# Fosse Green Energy

EN010154

28 April 2026

**8.14 Statement of Common Ground with Prax / BPA**

FIGURE TITLE
400KV PIPELINE CROSSING
FIGURE NUMBER
Figure 1-1
REV.
01

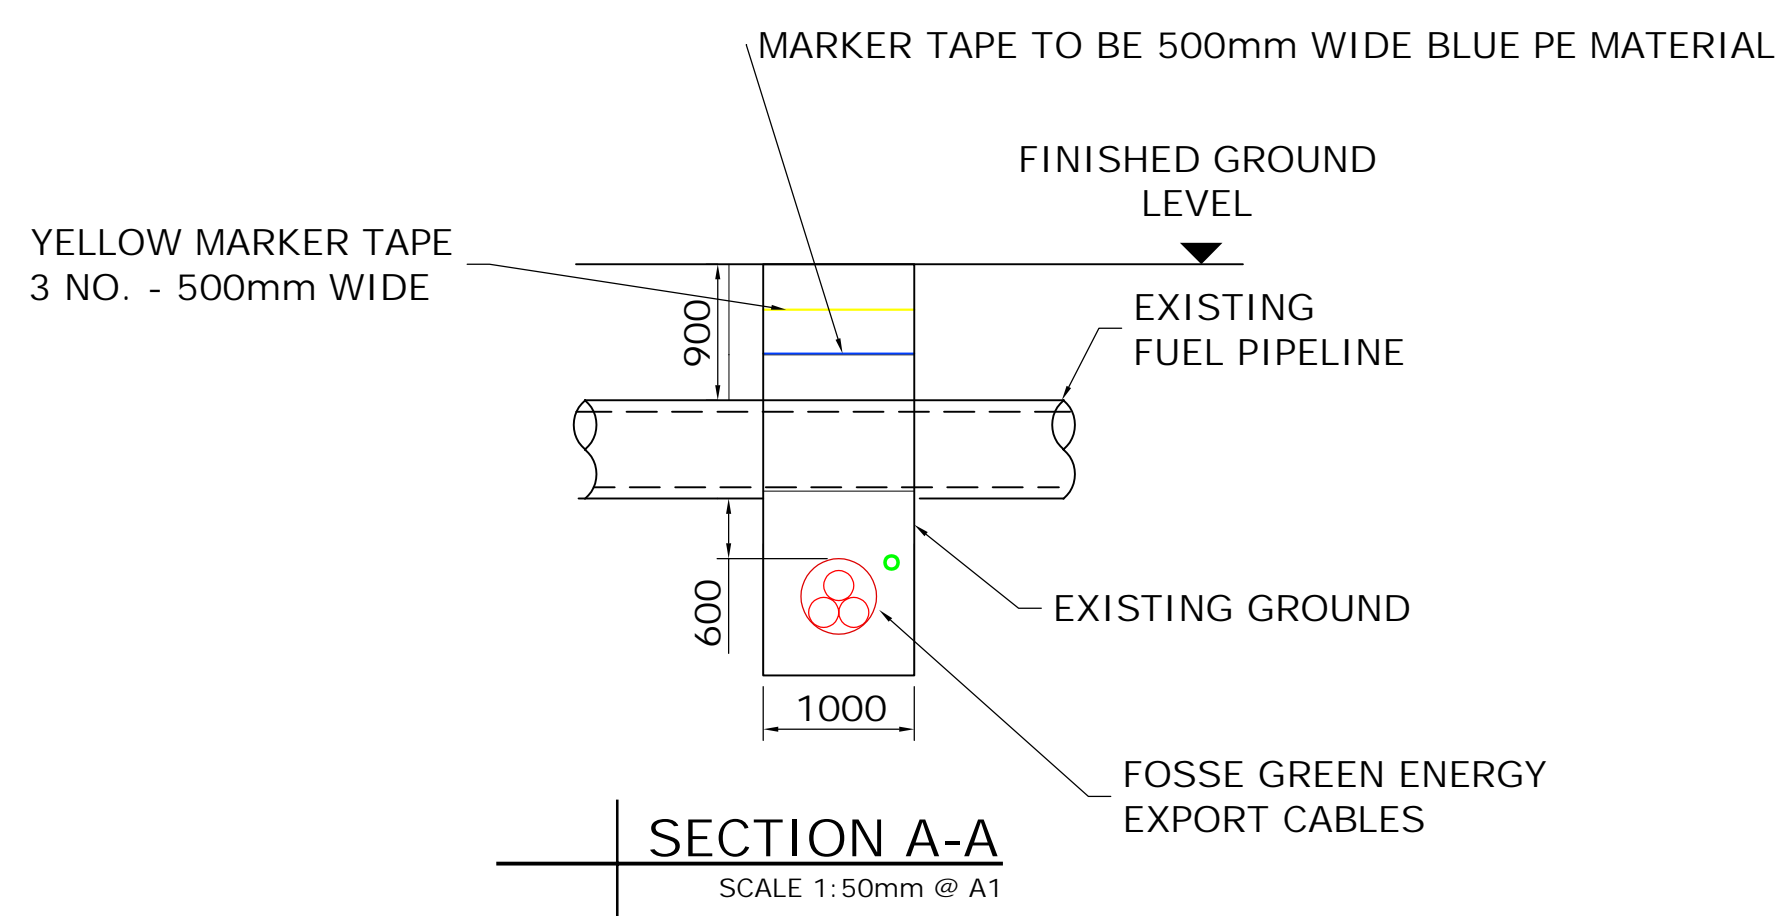
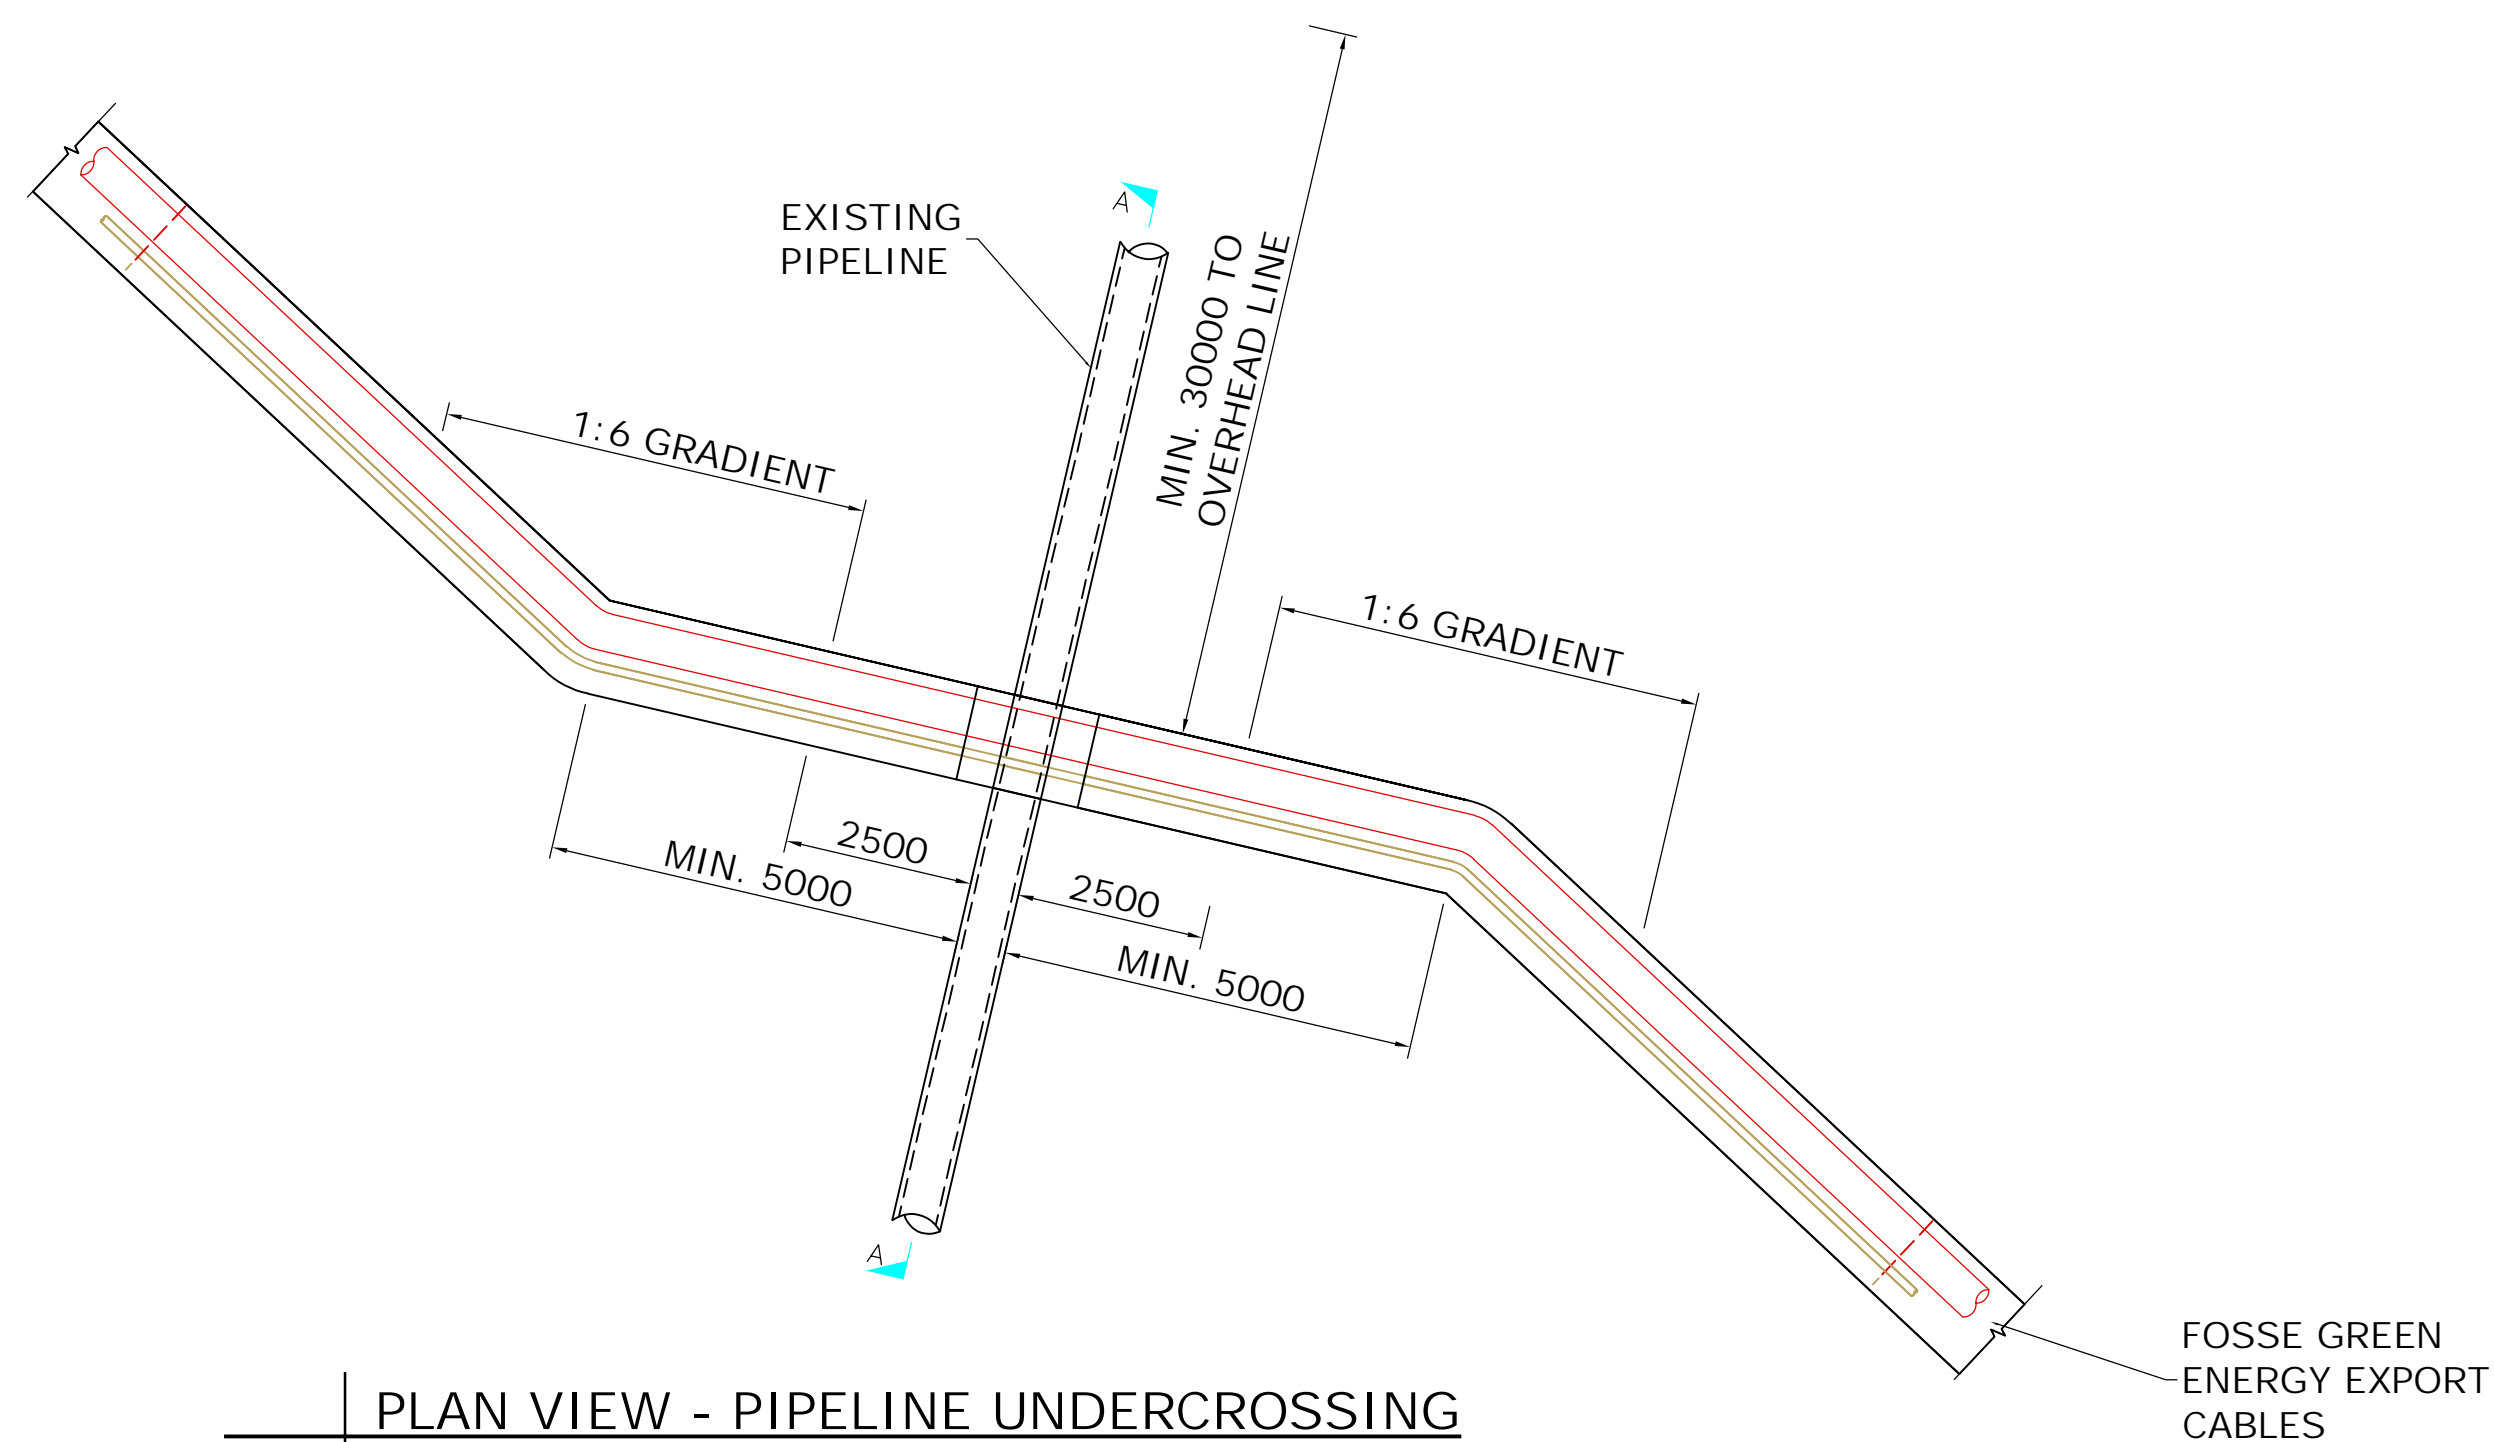
Reference	Description of Matter	Prax Position	Applicant Position	Status
4.2.1	Pipeline crossing	<p>The Proposed Development will involve the crossing of the Prax Pipeline with a high voltage electricity cable ("the Cable"). The Cable will be laid underground in close proximity to the Prax Pipeline. <u>Prax has fundamental concerns relating to (inter alia) risk and safety assessments relating to the proposed interaction with the Prax Pipeline, the ability for the Proposed Development to be carried out safely within the Order limits, the ability of the Order to deliver the necessary rights for any necessary mitigation, and the lack of agreement in respect of appropriate protective provisions and indemnities.</u></p> <p>The following information is therefore required:</p> <ul style="list-style-type: none"> <li>a) <del>(a)</del> full details what works and working methods are proposed within 20 meters of the Prax Pipeline; and</li> <li>b) <del>(b)</del> how close the Project Works will be to the Prax Pipeline and</li> </ul>	<p>The Applicant's position with regard to the AC Interference Modelling Study (or Risk Assessment) is identified at matter 3.1.2.</p> <p>The Applicant is in the process of negotiating bespoke protective provisions with FF <u>alongside these investigations and provided comments on FF's draft protective provisions on 22 April 2026, and following receipt of comments from FF on 24 April, provided further comments on 27 April 2026.</u></p> <p>Further information on the proposed works, offset distances, and crossing angle <u>will be are provided in the updated AC interference modelling report and engagement is continuing with Prax to secure appropriate protective provisions which reflect this.</u></p>	Under discussion

Reference	Description of Matter	Prax Position	Applicant Position	Status
		<p>modelling data to show the predicted levels of AC (Alternate Current) interference ("AC interference") likely to be caused thereby and whether these are within British Standard safety limits; and</p> <p>c) <del>(c)</del> whether a final decision has been made as to the crossing angle currently proposed in respect of the Prax Pipeline (as this will have a direct impact on AC interference). Initial discussions have indicated that the Applicant wishes to cross the Prax Pipeline at a 60 degree crossing angle. An angle less than 90 degrees of crossing will make the need for mitigation more likely; and</p> <p>d) <del>(d)</del> what mitigation works (if any) are envisaged to:</p> <ul style="list-style-type: none"> <li>(i) <del>(i)</del> safeguard the Prax Pipeline from physical harm during the works, and</li> <li>(ii) <del>(ii)</del> to protect the Prax Pipeline in the future</li> </ul>

Reference	Description of Matter	Prax Position	Applicant Position	Status
		<p>(once the Cable is energized) from potential damage from AC interference, as this could seriously damage the measures currently in place to protect the Prax Pipeline from corrosion; and</p> <p>e) <del>(e)</del> to the extent that mitigation measures are necessary (due to operational or safety concerns) that the draft Order has included the necessary land and rights within the draft Order limits. Typically mitigation works might require:</p> <ul style="list-style-type: none"> <li>(i) the installation of multiple subsurface 'sacrificial' zinc strips either side of and parallel to the Prax Pipeline together with surface mounted monitoring equipment and surface to subsurface cabling); and/or</li> <li>(ii) the installation of a concrete or other barrier</li> </ul>

Reference	Description of Matter	Prax Position	Applicant Position	Status
		<p>above or below the Prax Pipeline; and/or (iii) a concrete 'raft' above the Prax Pipeline to protect against vehicles / other loads).</p> <p><u>Prax's position is further outlined at 3.1.1 and in AS-129. While the initial work undertaken to date is sufficient to confirm that there is a credible threat to the pipeline infrastructure, it is not yet possible to quantify the effectiveness or sufficiency of any potential mitigation measures</u></p>
